Date: 25th April 2019

Planning Application 3/2019/0331: Creation of a new off-road, multi-use link between the villages of Downham and Chatburn. The one kilometre connection would accommodate walkers, cyclists, horse-riders and those with mobility issues including chair users. Resubmission of planning application 3/2018/0754. Chatburn Road, Clitheroe BB7 4BJ

HOLDING AREA : TYPICAL CONSTRUCTION : FRONT VIEW - NTS

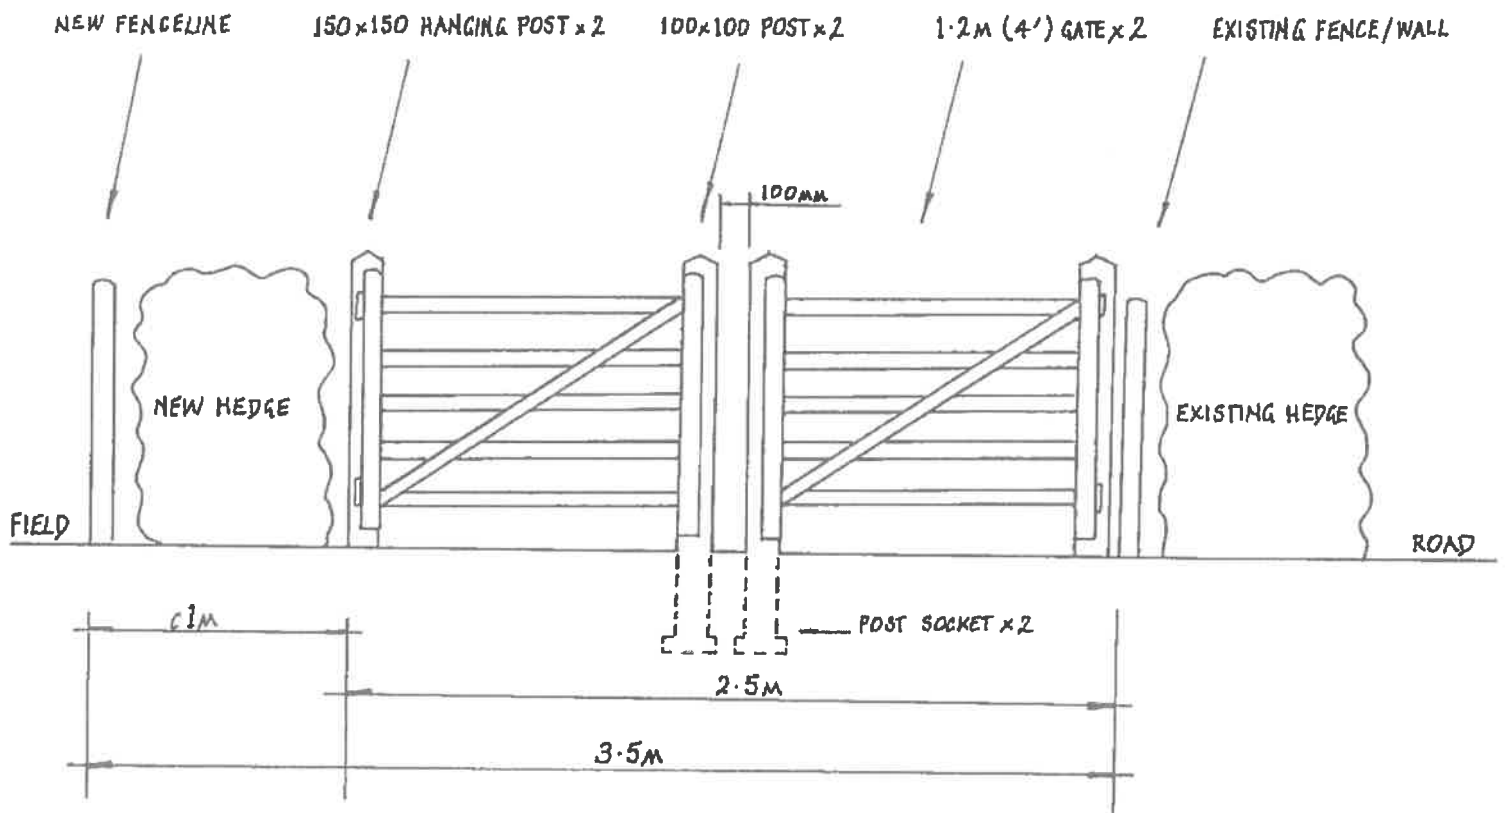
"... the only mitigation that will be required ... will be a formal archaeological watching brief during groundworks within the field crossed by the Roman road. This will need to include agreeing the exact location of the posts for the new access (above), once the road remains have been exposed."

- (i) A formal archaeological watching brief during the groundworks required in the field crossed by the Roman road;
- (ii) Agreement of the location of the location of any new posts required for the hurdle closures to the agricultural crossing of the new link within the field; and
- (iii) The production and submission of a report on the work undertaken and the results obtained.
